## OFFICIAL NOTIFICATION OF DECISION

**Project# PR-2021-006238**  
**Application#**  
**SI-2021-01916 SITE PLAN**  
**SD-2022-00001 PRELIMINARY/FINAL PLAT**

For all or a portion of: **LOTS 15-18, BLOCK 20 UNITS A and B, NORTH ALBUQUERQUE ACRES** zoned **MX-L**, located at **ALAMEDA BLVD between SAN PEDRO AND LOUISIANA BLVD NE and JEFFERSON ST NE** containing approximately **2.77** acre(s). **(C-18)**

### **SI-2021-01916 SITE PLAN**

A1 SITE PLAN
1" = 30'-0"
0 30' 60'

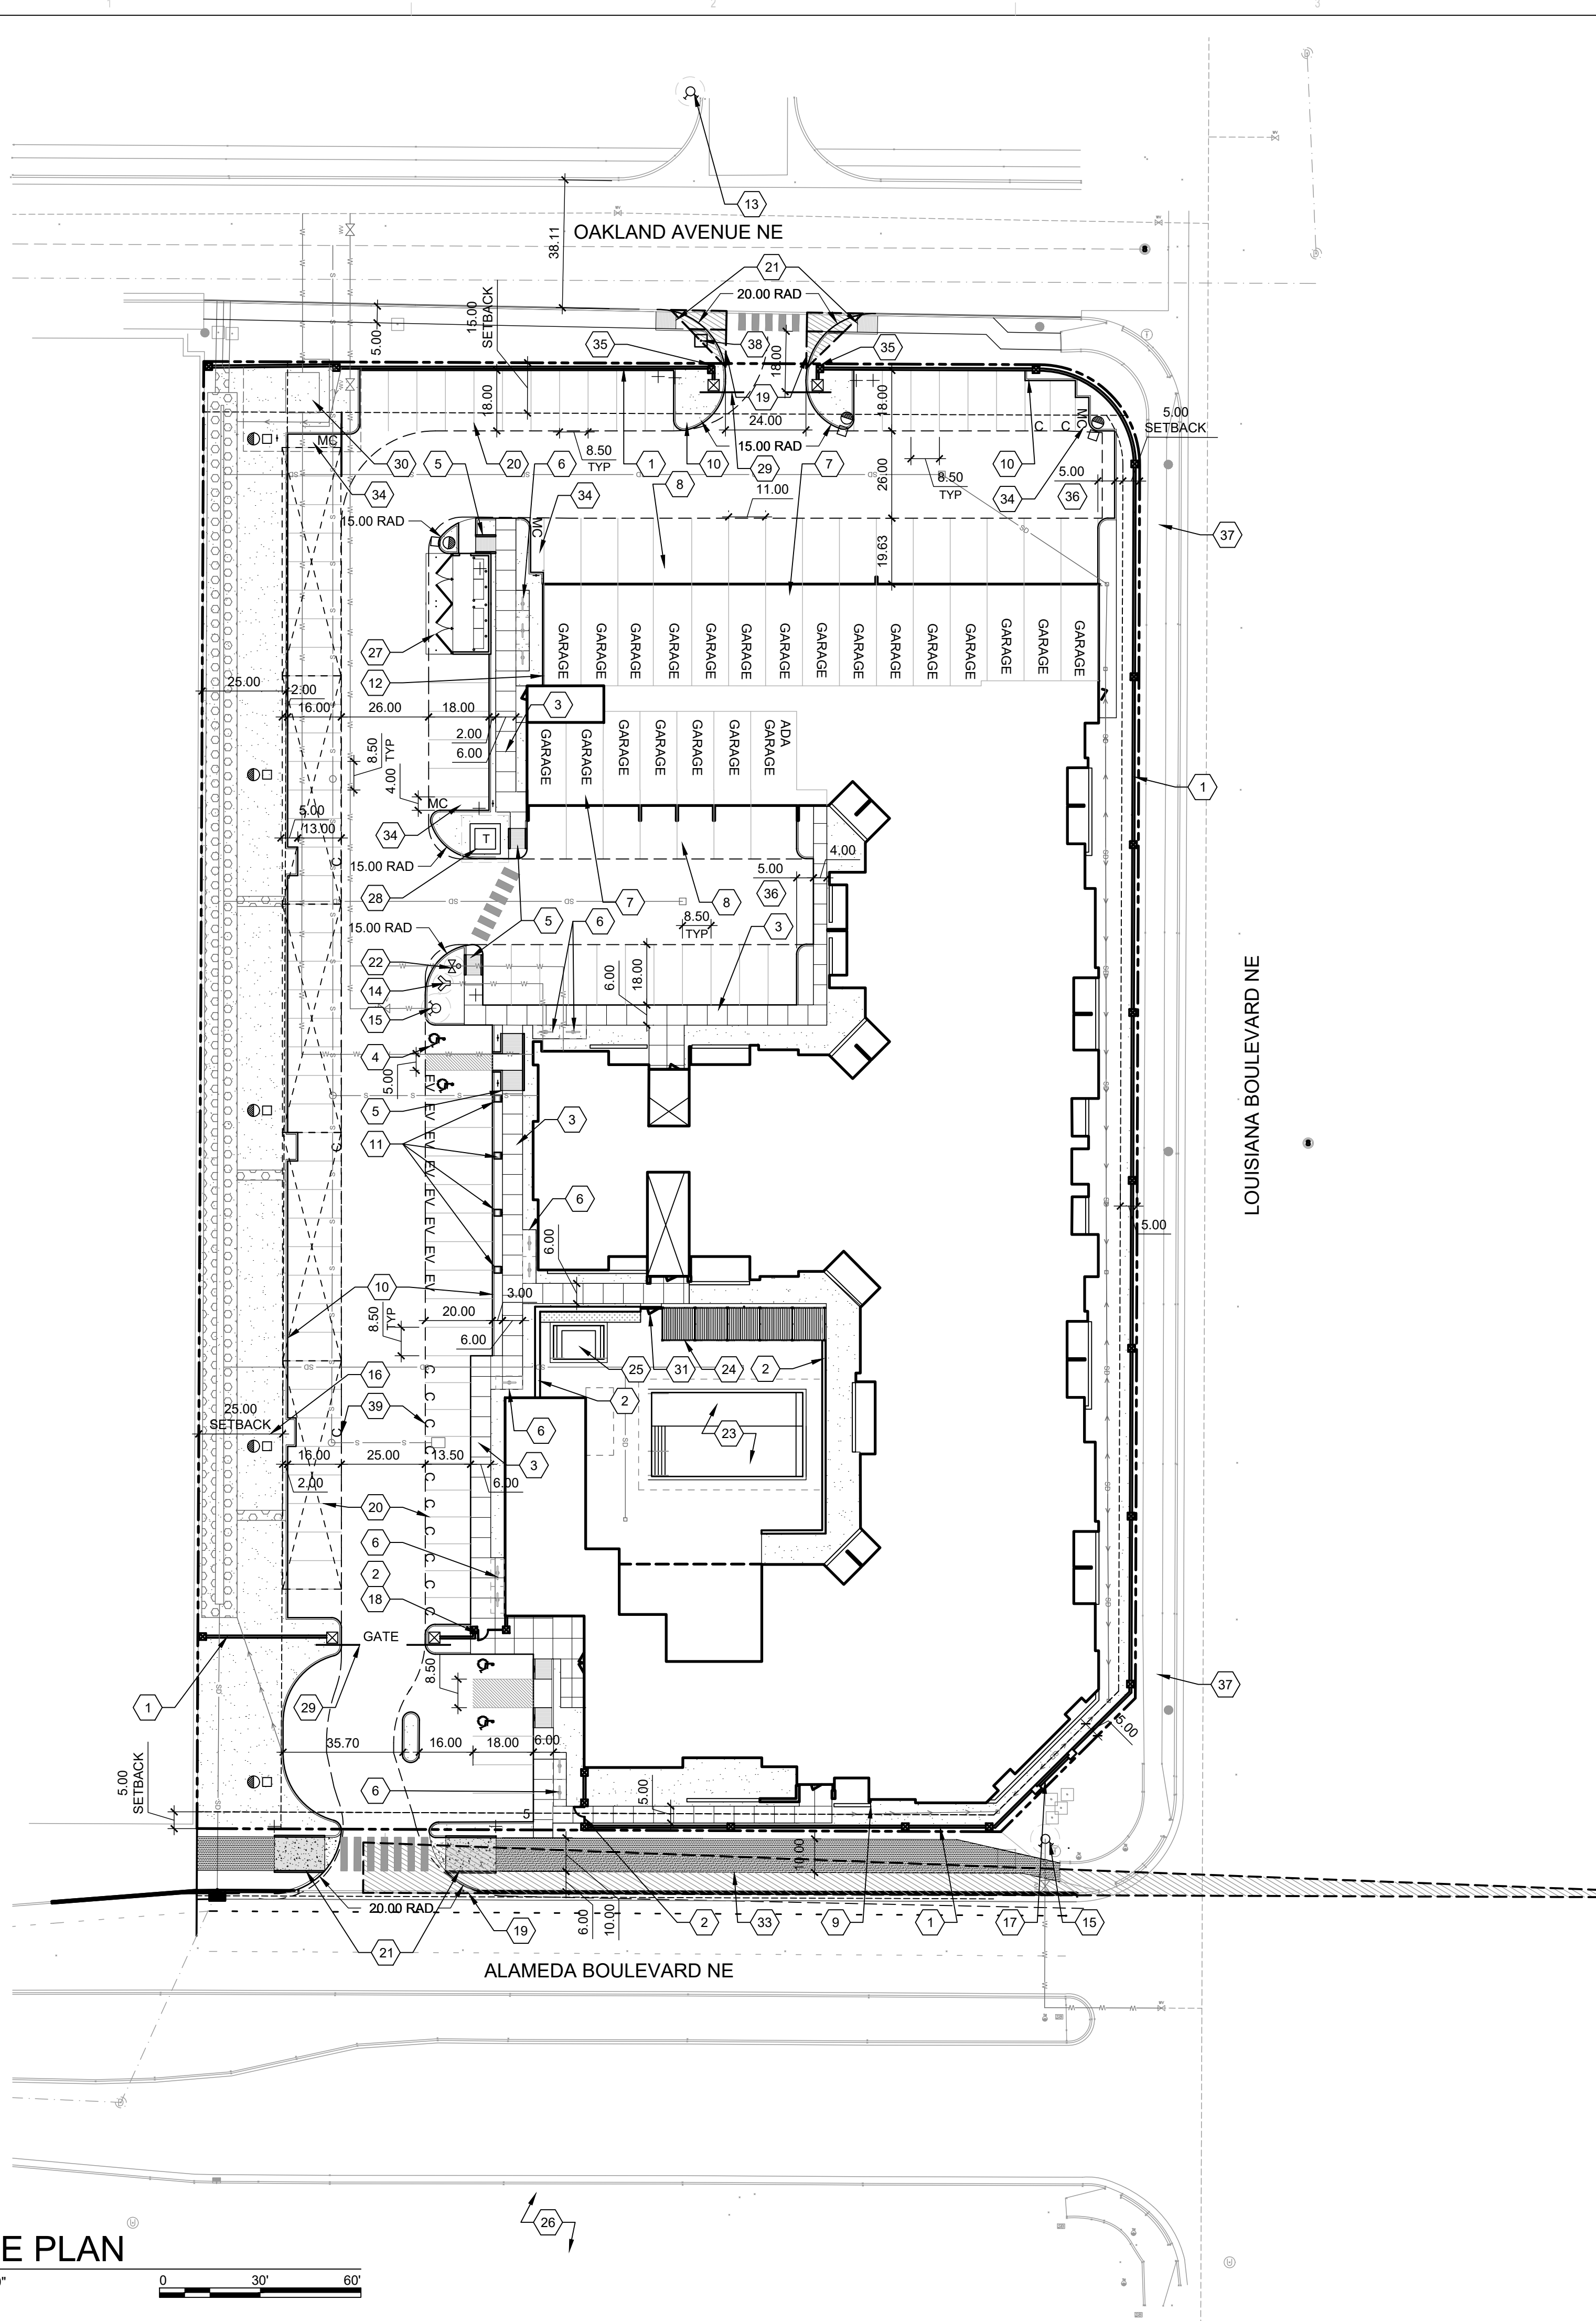
1. This Site Plan is valid 7 years from DRB approval (1/19/2022). An extension may be requested prior to the expiration date.
2. Final sign off is delegated to Transportation for a revision regarding clear site triangles and the minor labeling within the parking lot as discussed.
3. Final sign off is delegated to Planning for the DRB-signed Preliminary/Final Plat (SD-2022-00001), Solid Waste signature, and the recorded IIA.
4. The applicant will obtain final sign off from Transportation and Planning by March 16, 2022 or the case may be scheduled for the next DRB hearing and could be denied her the DRB Rules of Procedure.
